12409  
15 November 2013

**MODIFICATION TO APPROVED BOUTIQUE HOTEL (MP11\_0089)  
BLOCK 3A, CENTRAL PARK, CHIPPENDALE**

On behalf of Sonrac Developments Pty Ltd, we write to request that the Minister (or his delegate) modify Project Approval MP 11\_0089 under section 75W of the *Environmental Planning and Assessment Act 1979* as described below.

1 LEVEL 3
1:100

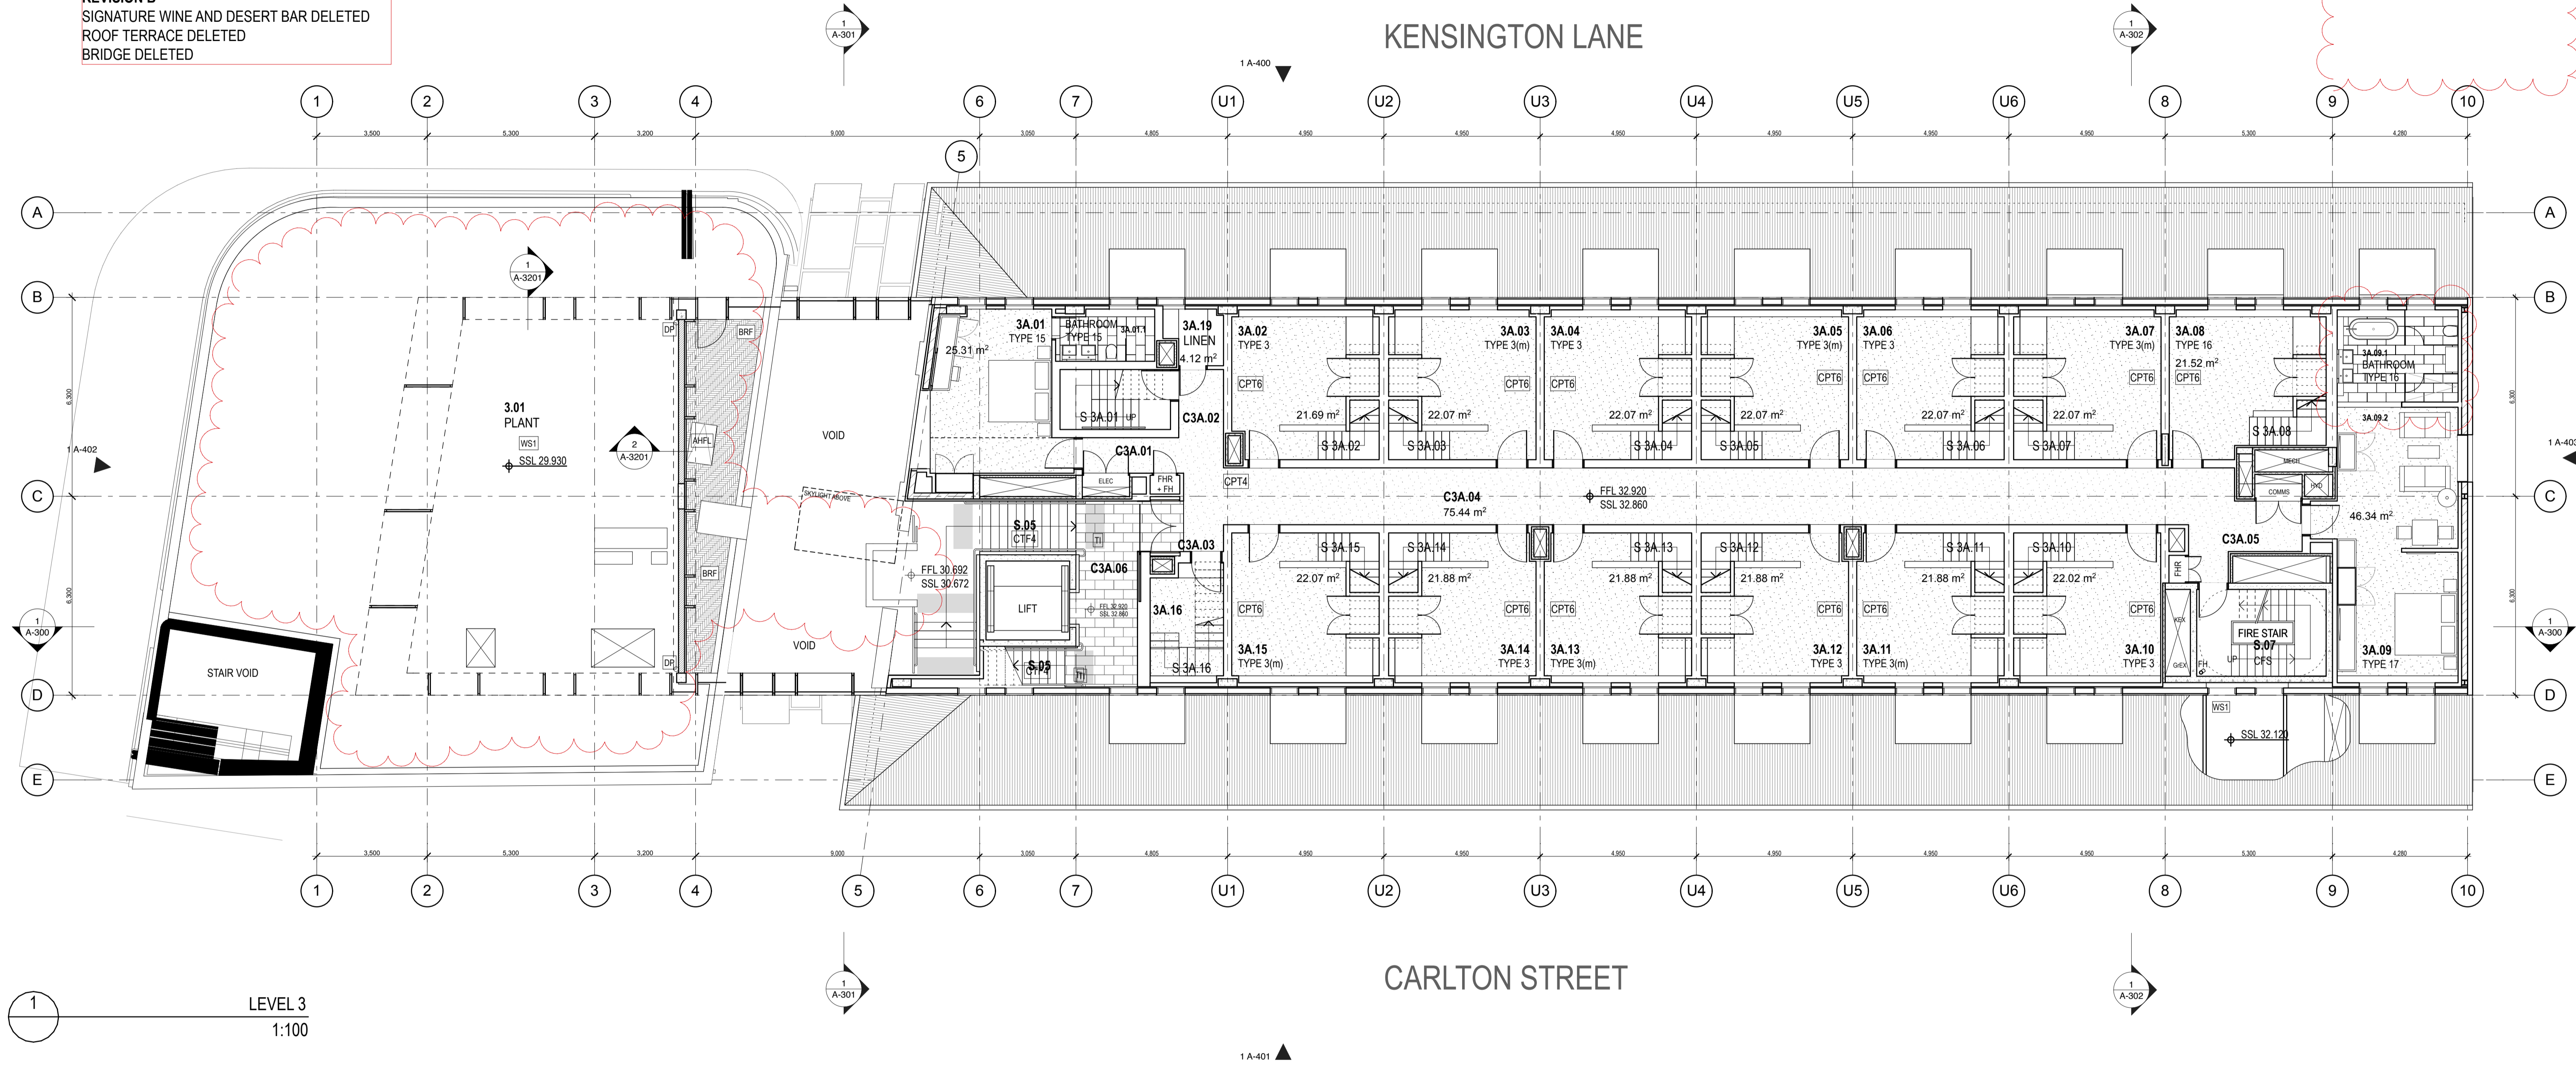
On level 3, the signature wine and dessert bar and adjoining roof terrace have been deleted, as has the bridge that provided a link between the hotel rooms and the bar. The deletion of the bar has allowed for necessary plant and services equipment.

1 ROOF TOP POOL
1:100

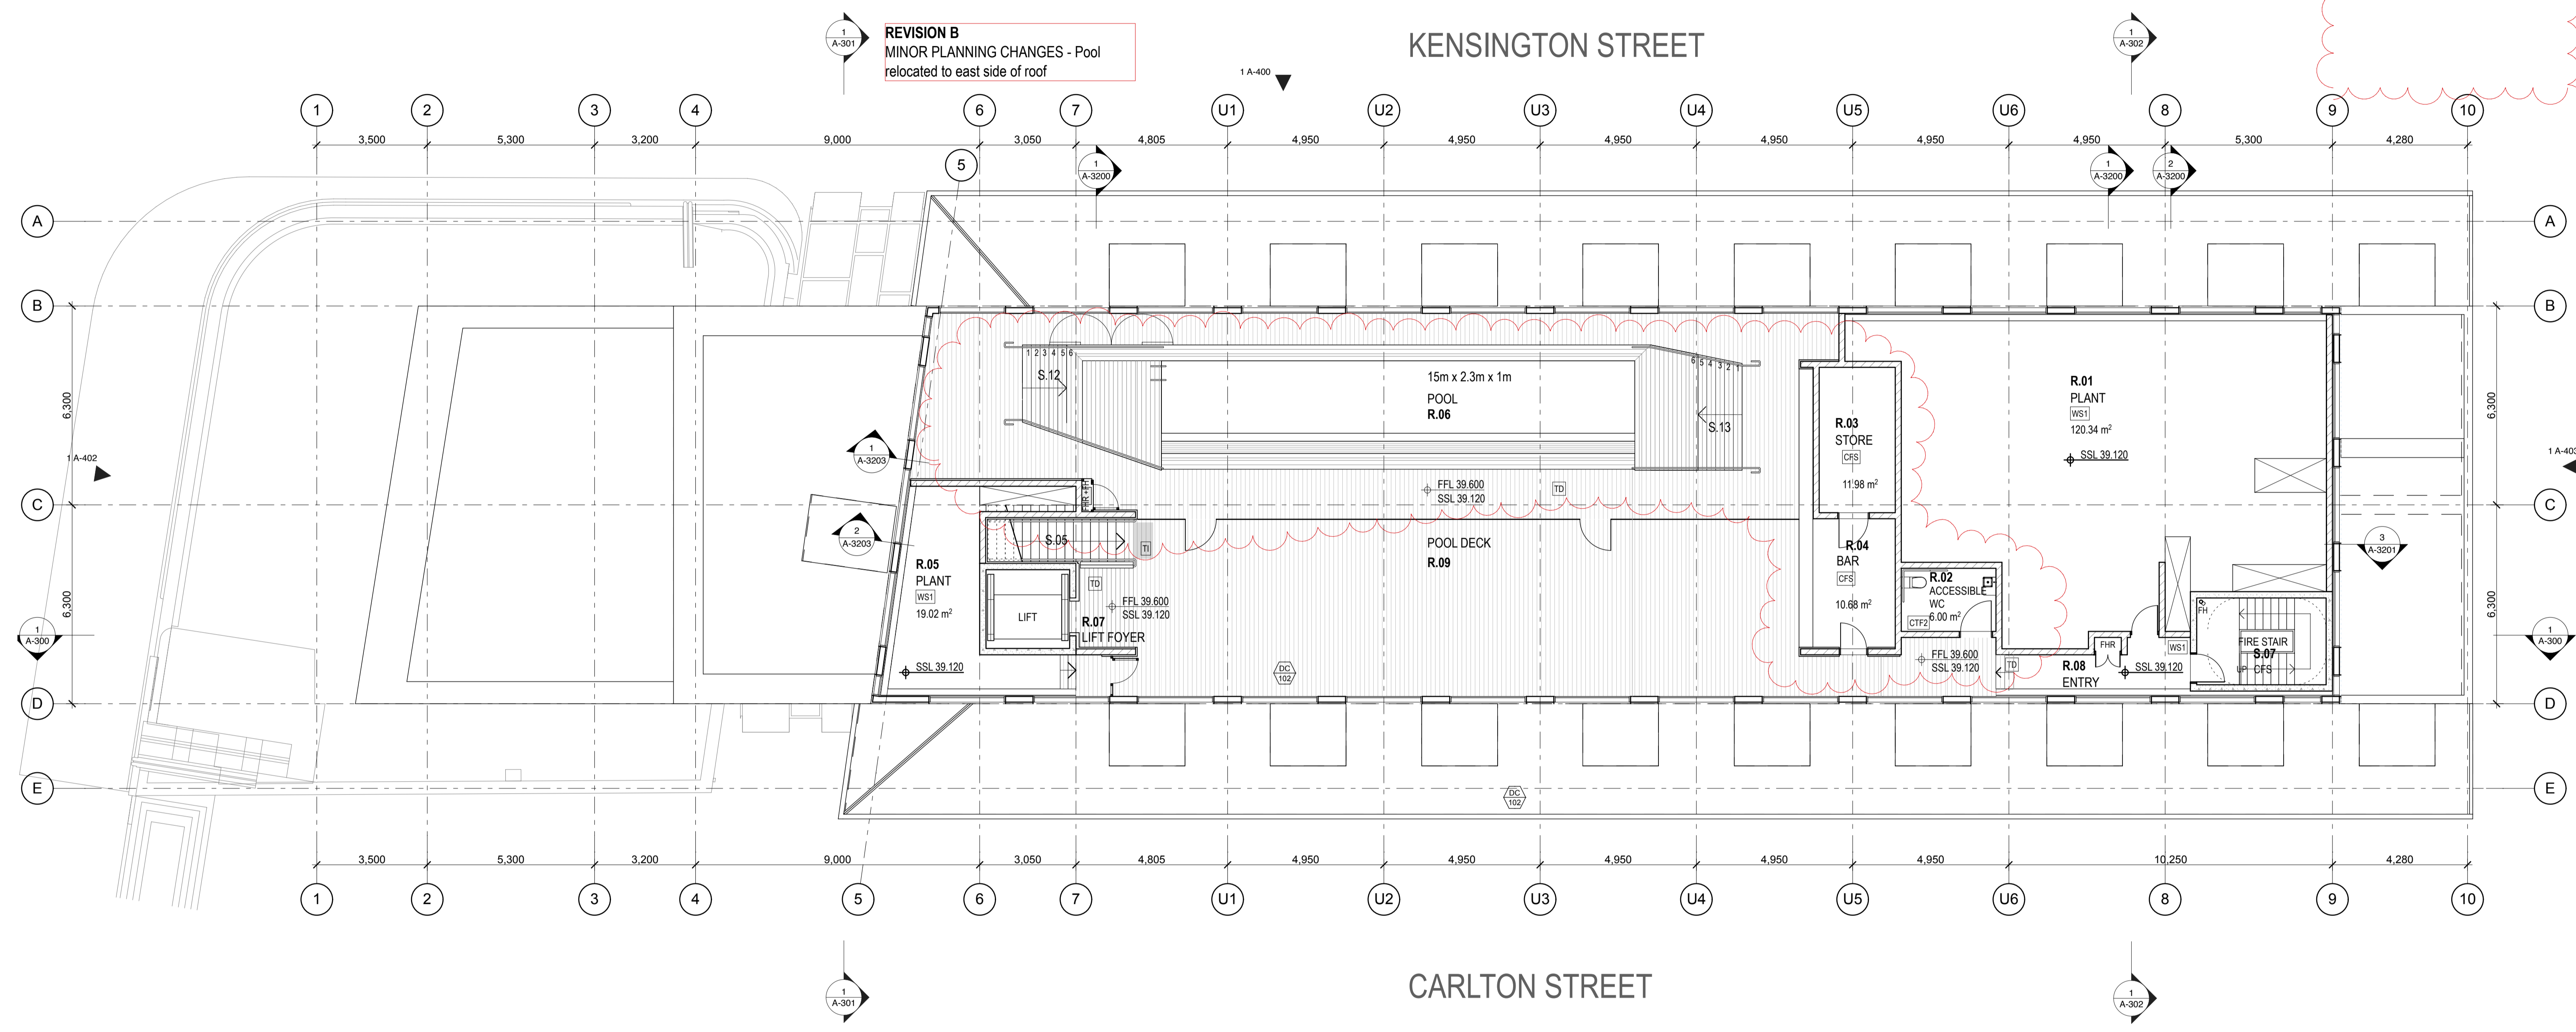
On the roof top, the pool has been relocated to the east to improve the overall layout, and the pool deck canopies have been raised by 100mm to accommodate the uses beneath.

1 SECTION 01
 1:100

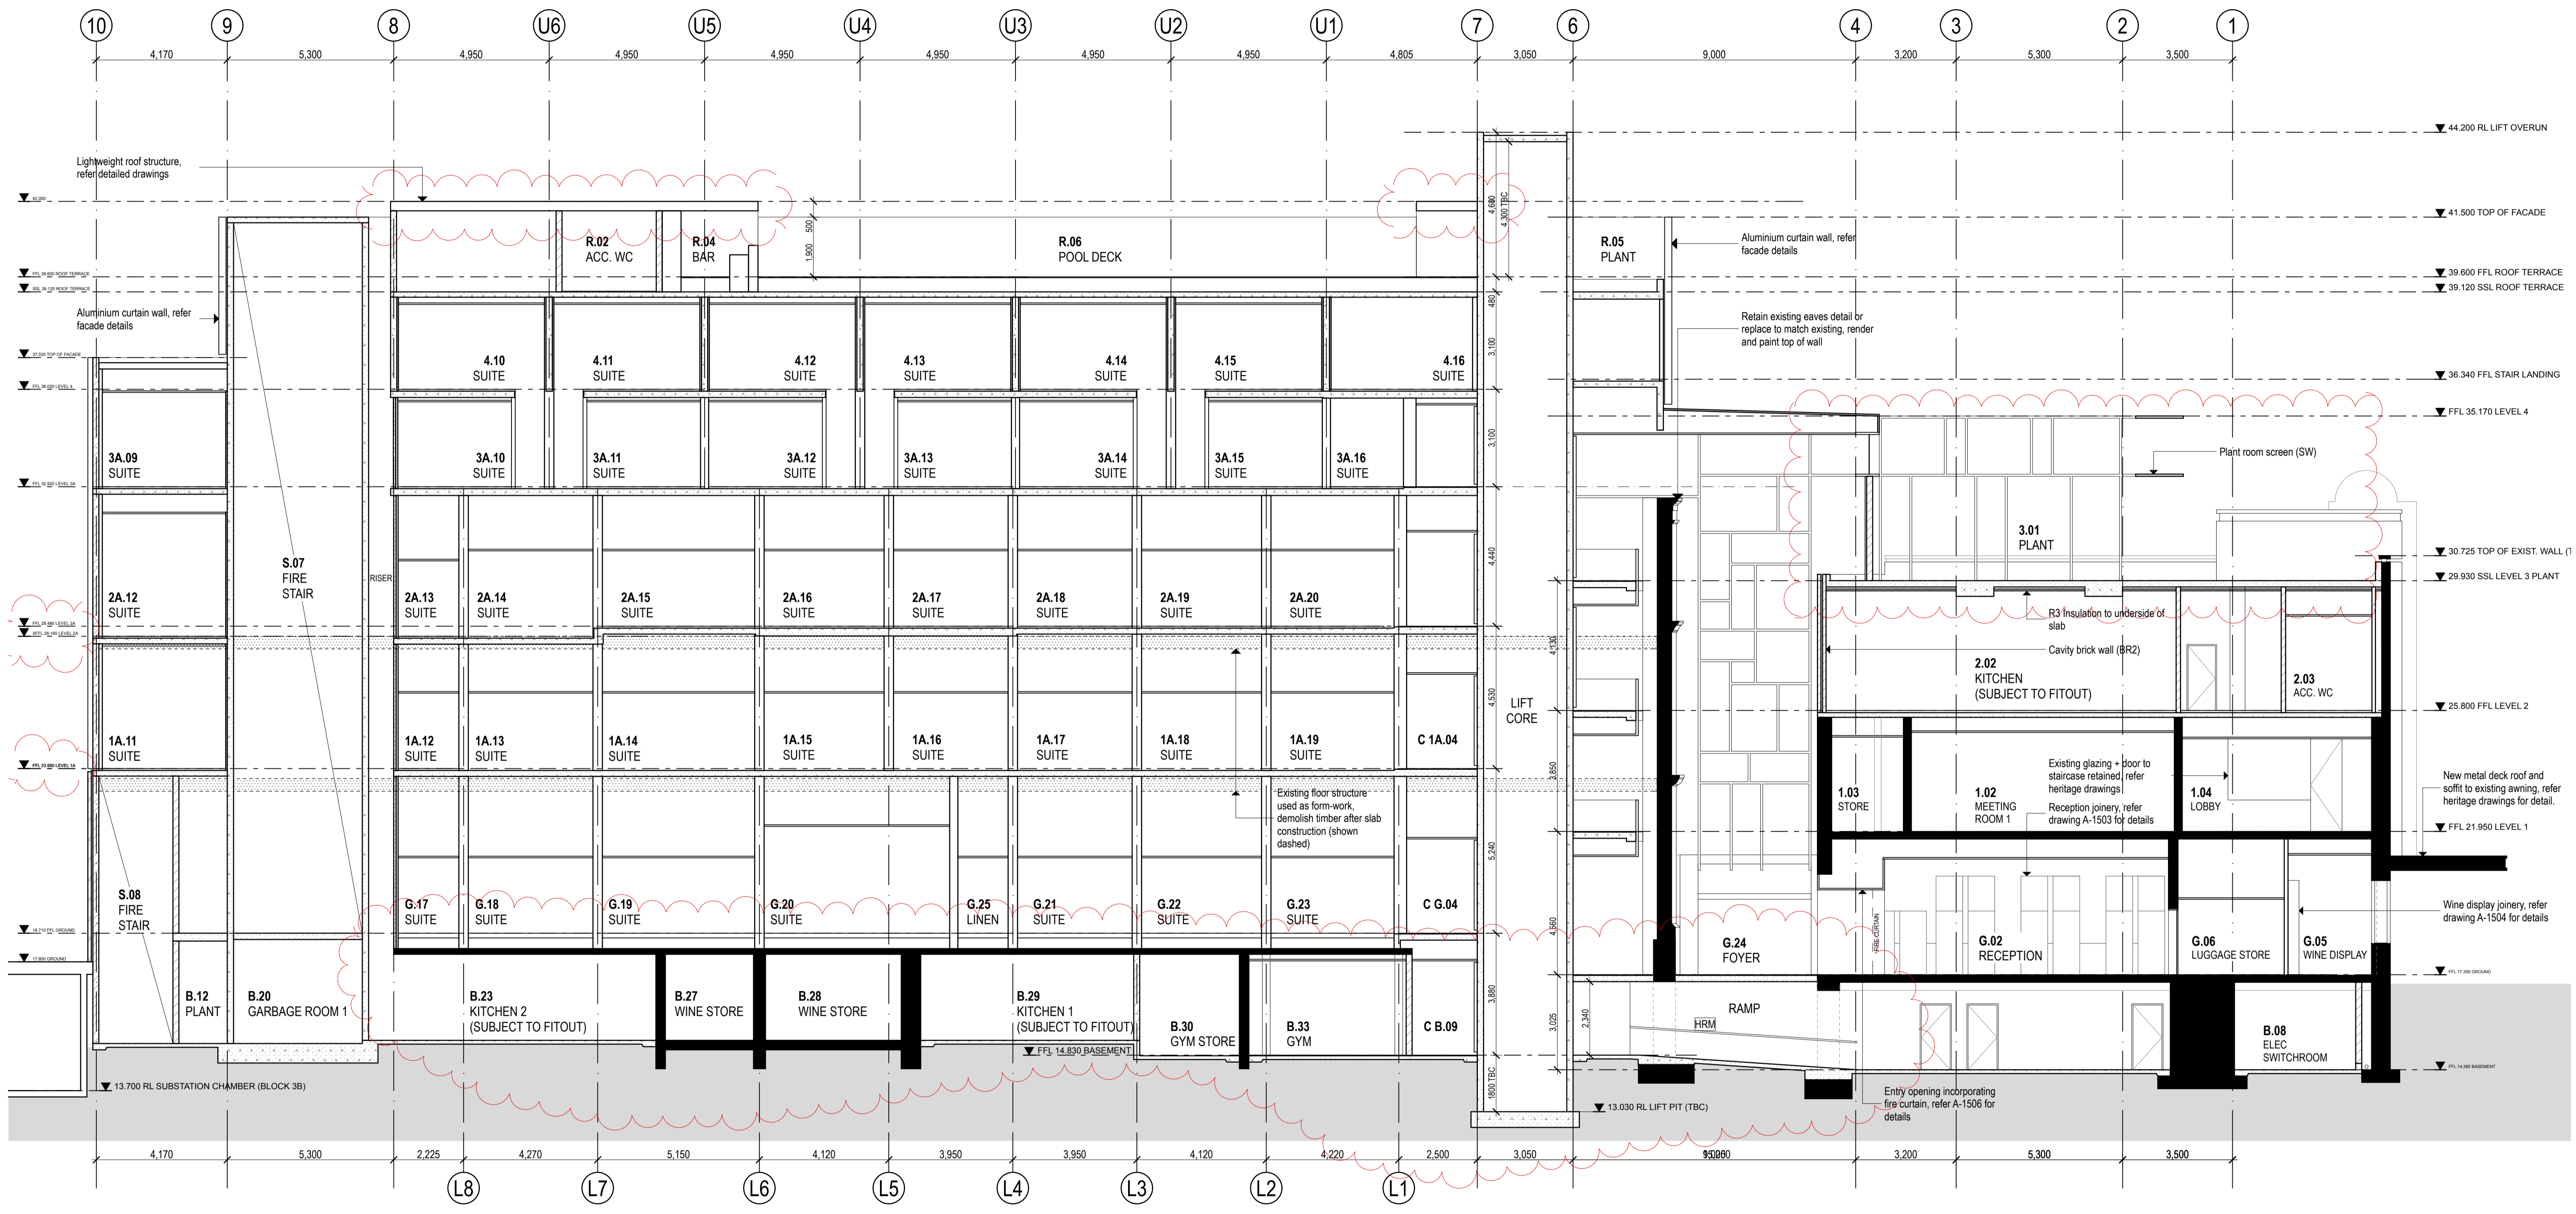
The proposed modification to the building envelope, which comprises raising the pool deck canopies, is minor and overall the height of the building remains generally consistent with that which was approved.
